KITTITAS VALLEY FIRE & RESCUE

KVFR Prevention SEPA Comments

Project: Nunnally Project
Permit#: SE-21-00006
Date: 06/06/2022

HANSEN ROAD DEVELOPMENT
ROADWAY PLANS
PROPOSED ROAD GRADING PLAN & PROFILE

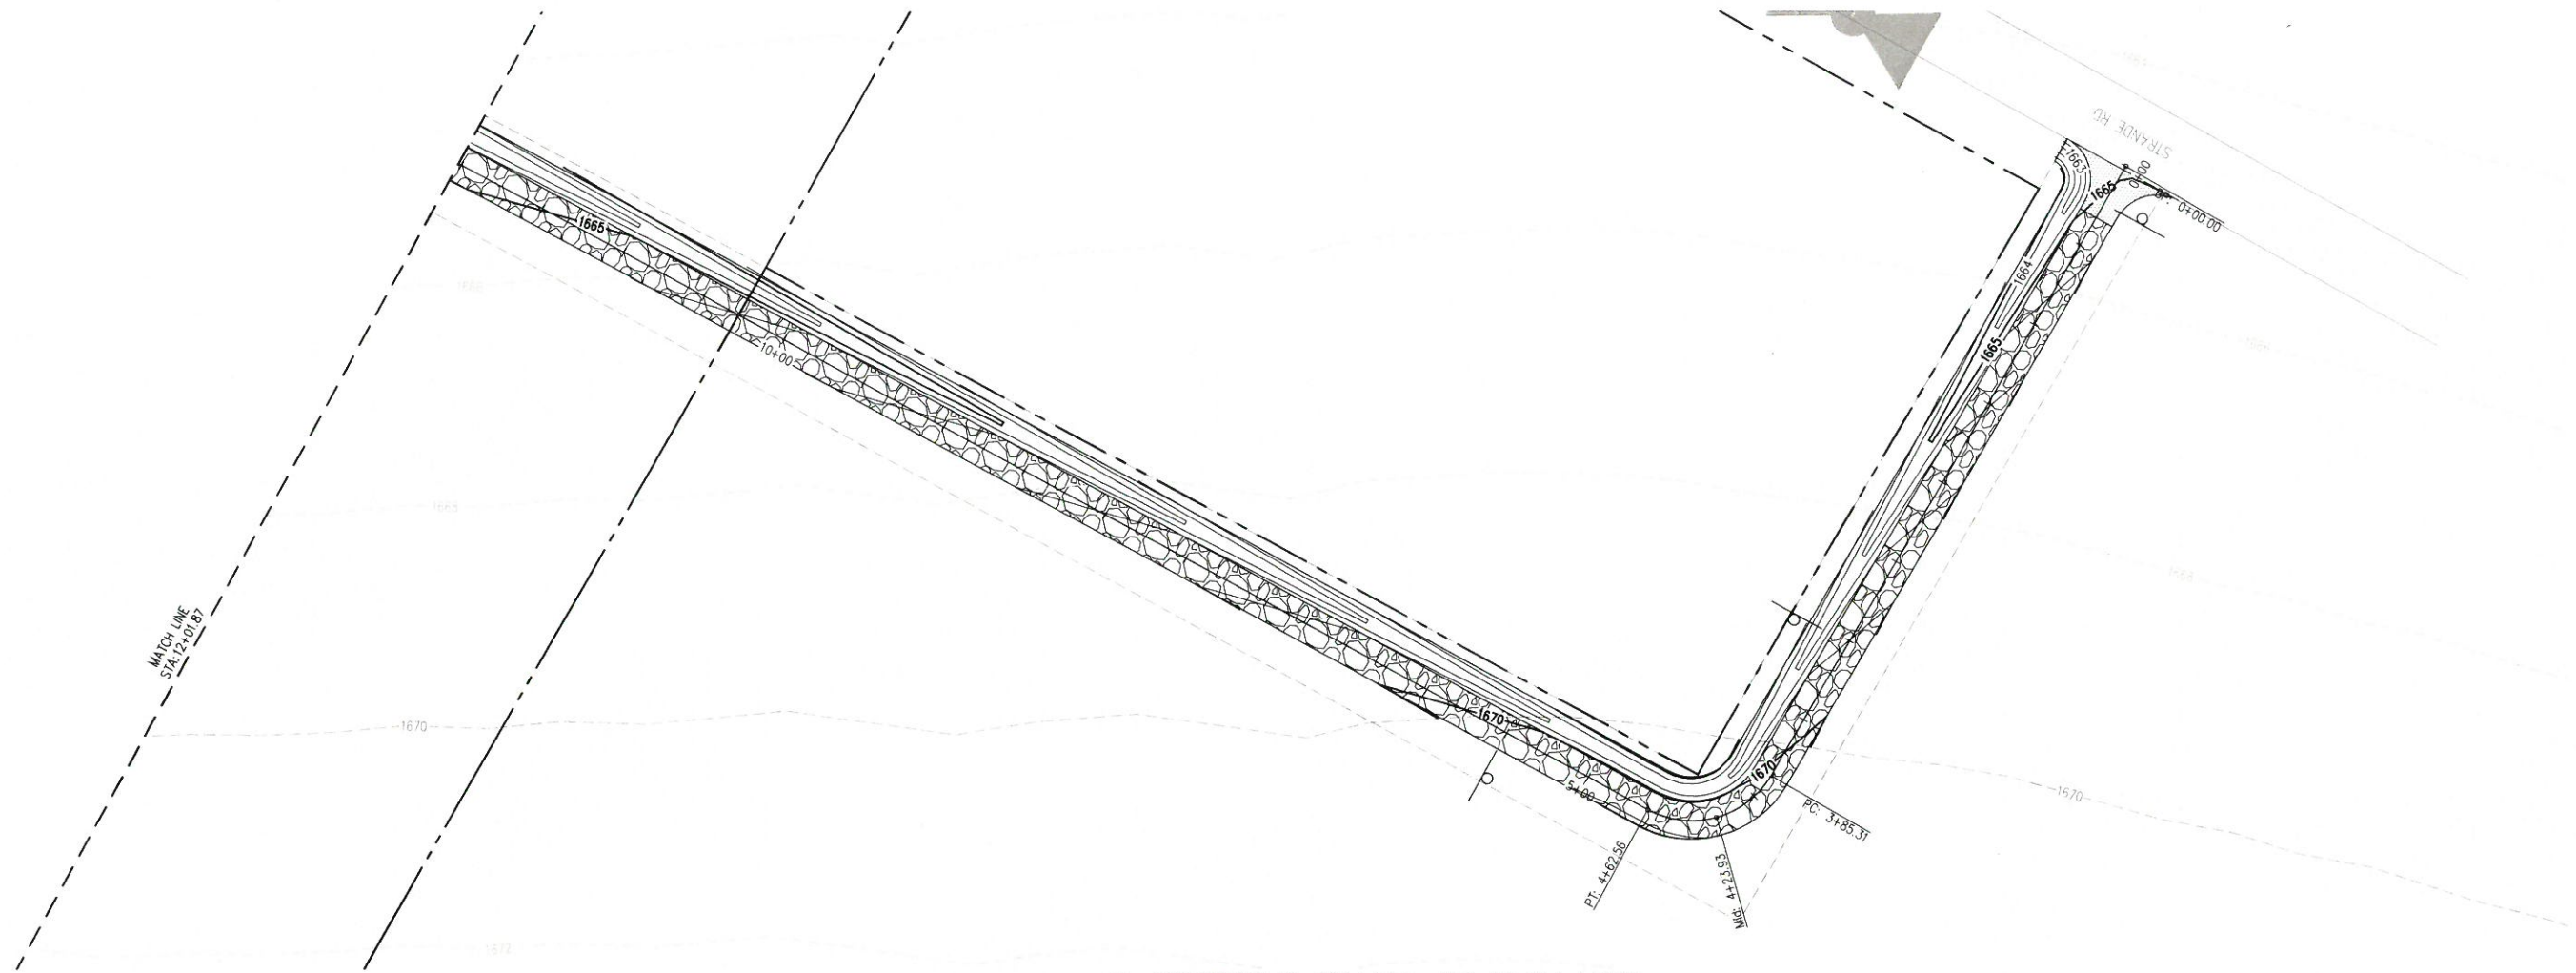
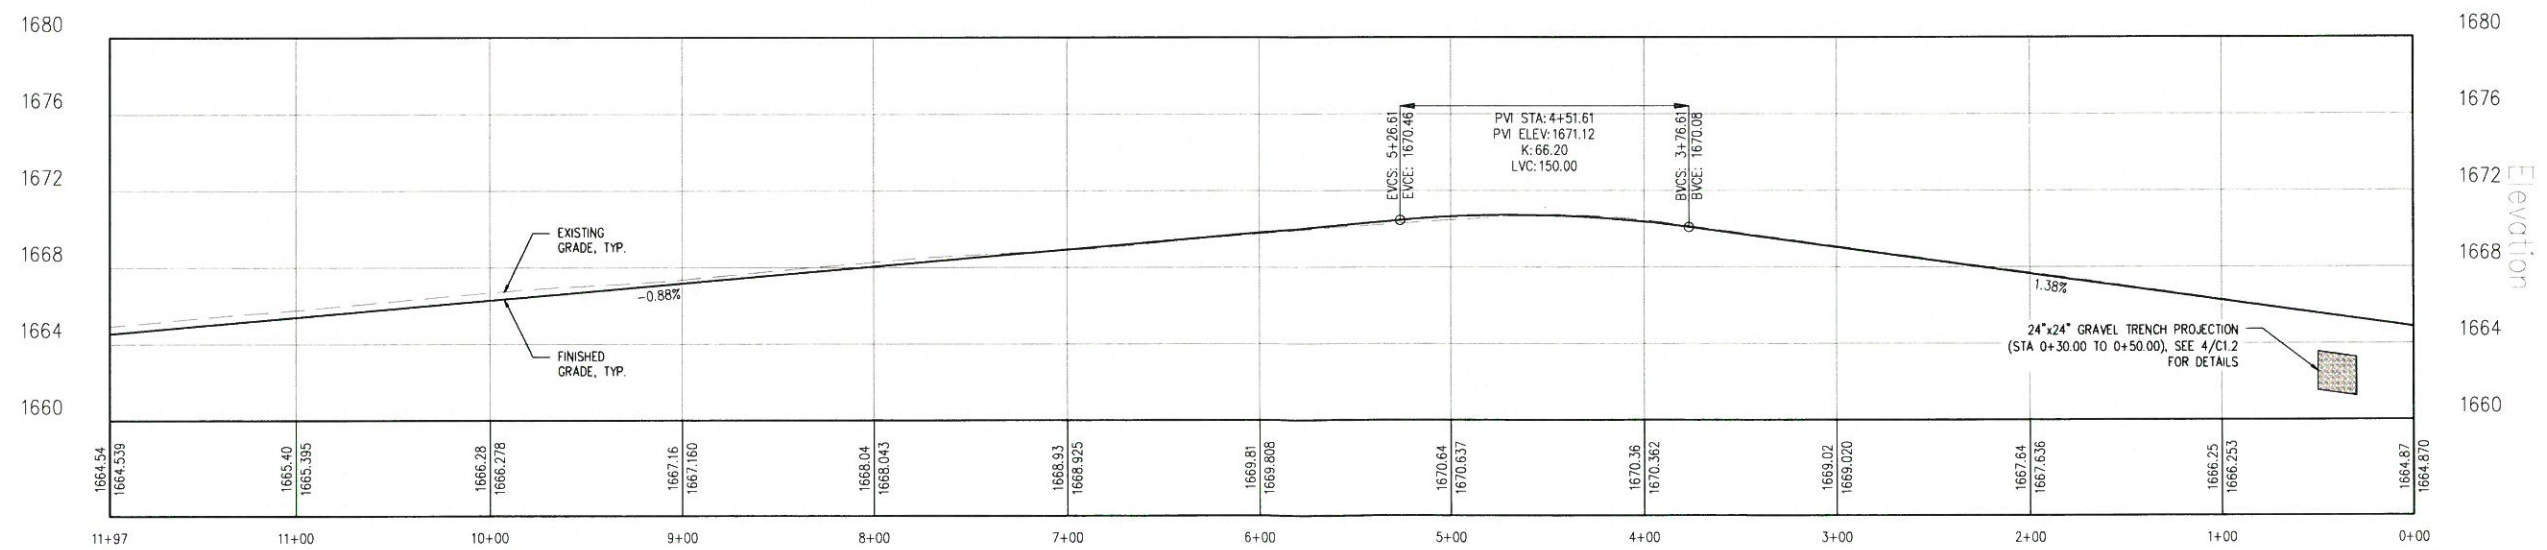
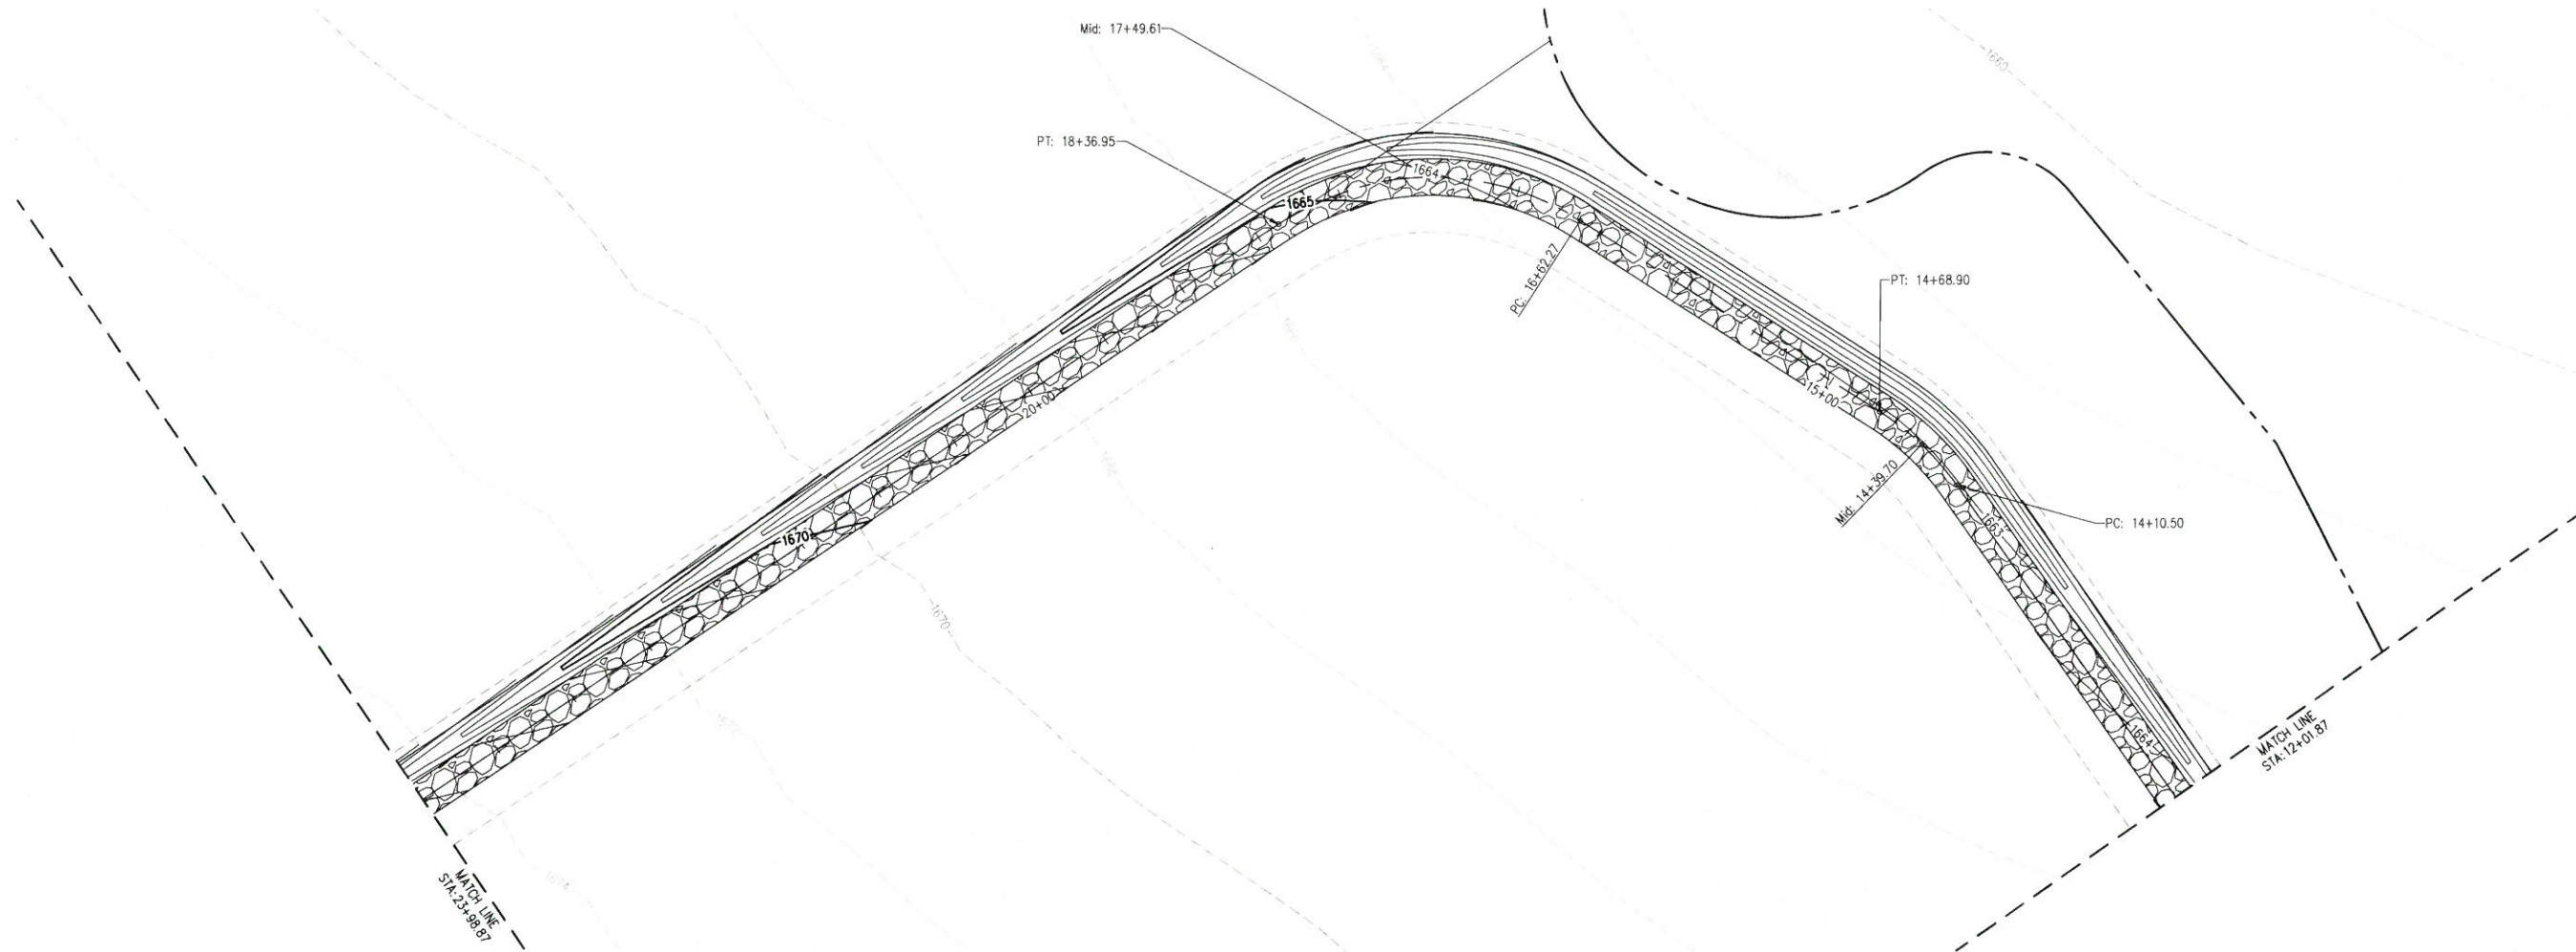
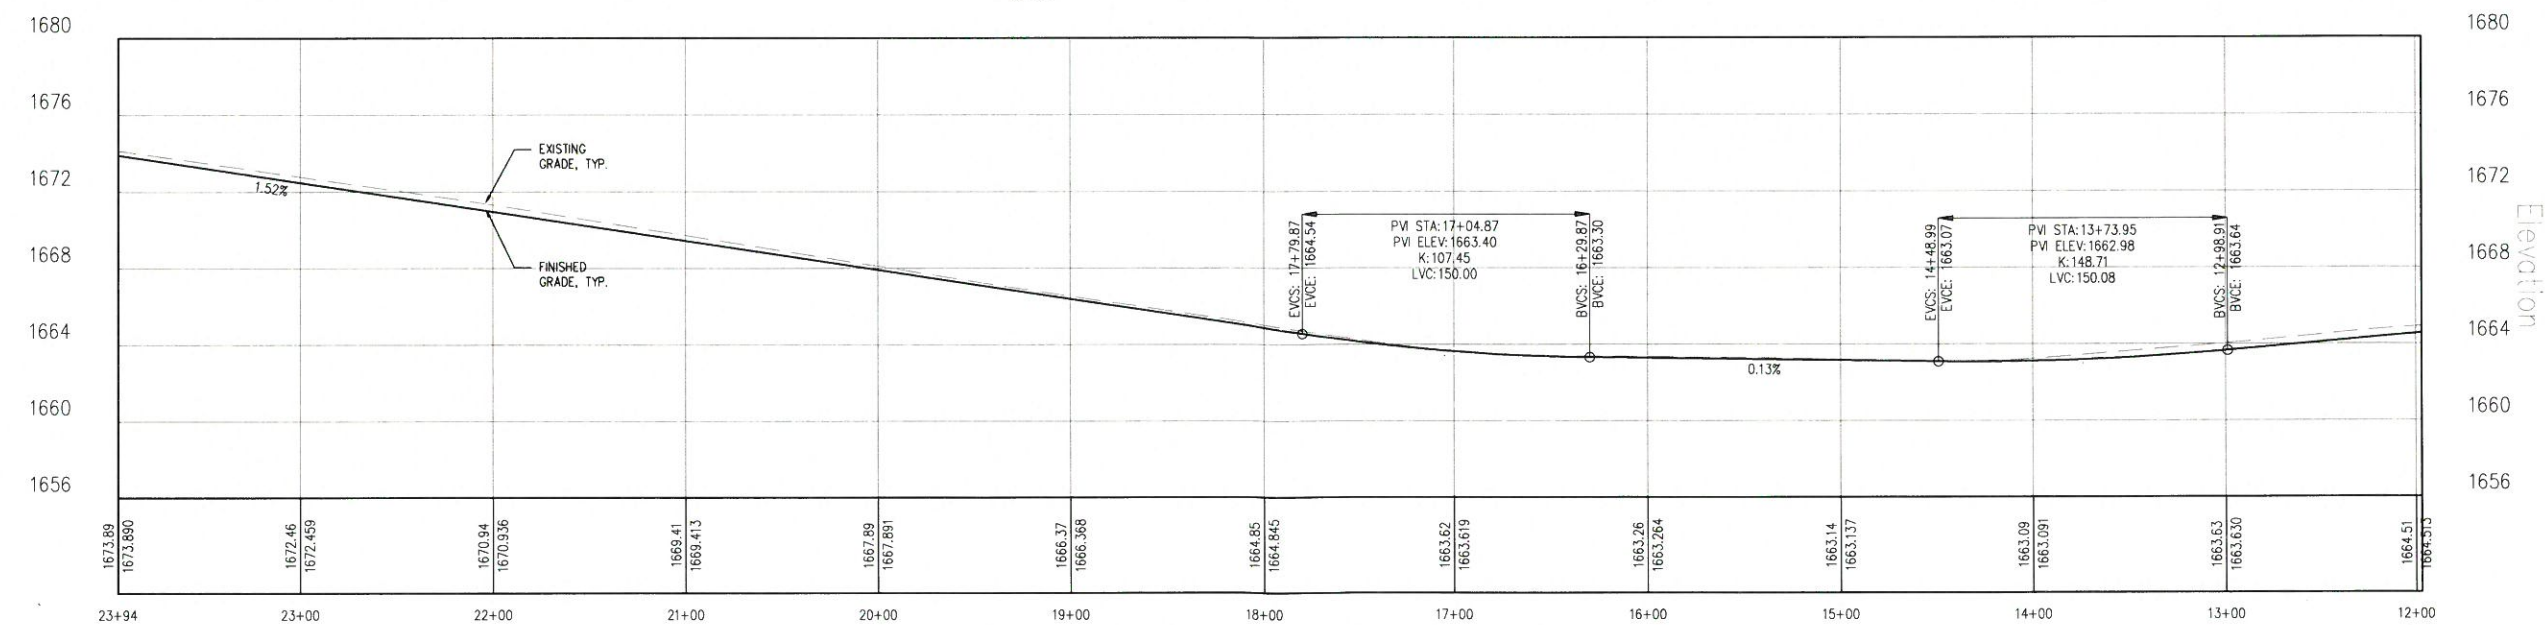
- Fire apparatus access roads exceeding 150' shall be provided with a temporary or permanent turnaround meeting the requirement 2018 IFC Appendix D.
- Fire apparatus access roads shall not exceed 10% in grade. This is especially critical in our valley's climate.
- The IFC Appendix D requires the road be a minimum of 20' wide and capable of supporting an imposed load of at least 75,000 lbs.
- Our standard turning radius is a minimum of 23' inside and 45' outside.
- Water supply meeting Kittitas County requirements.
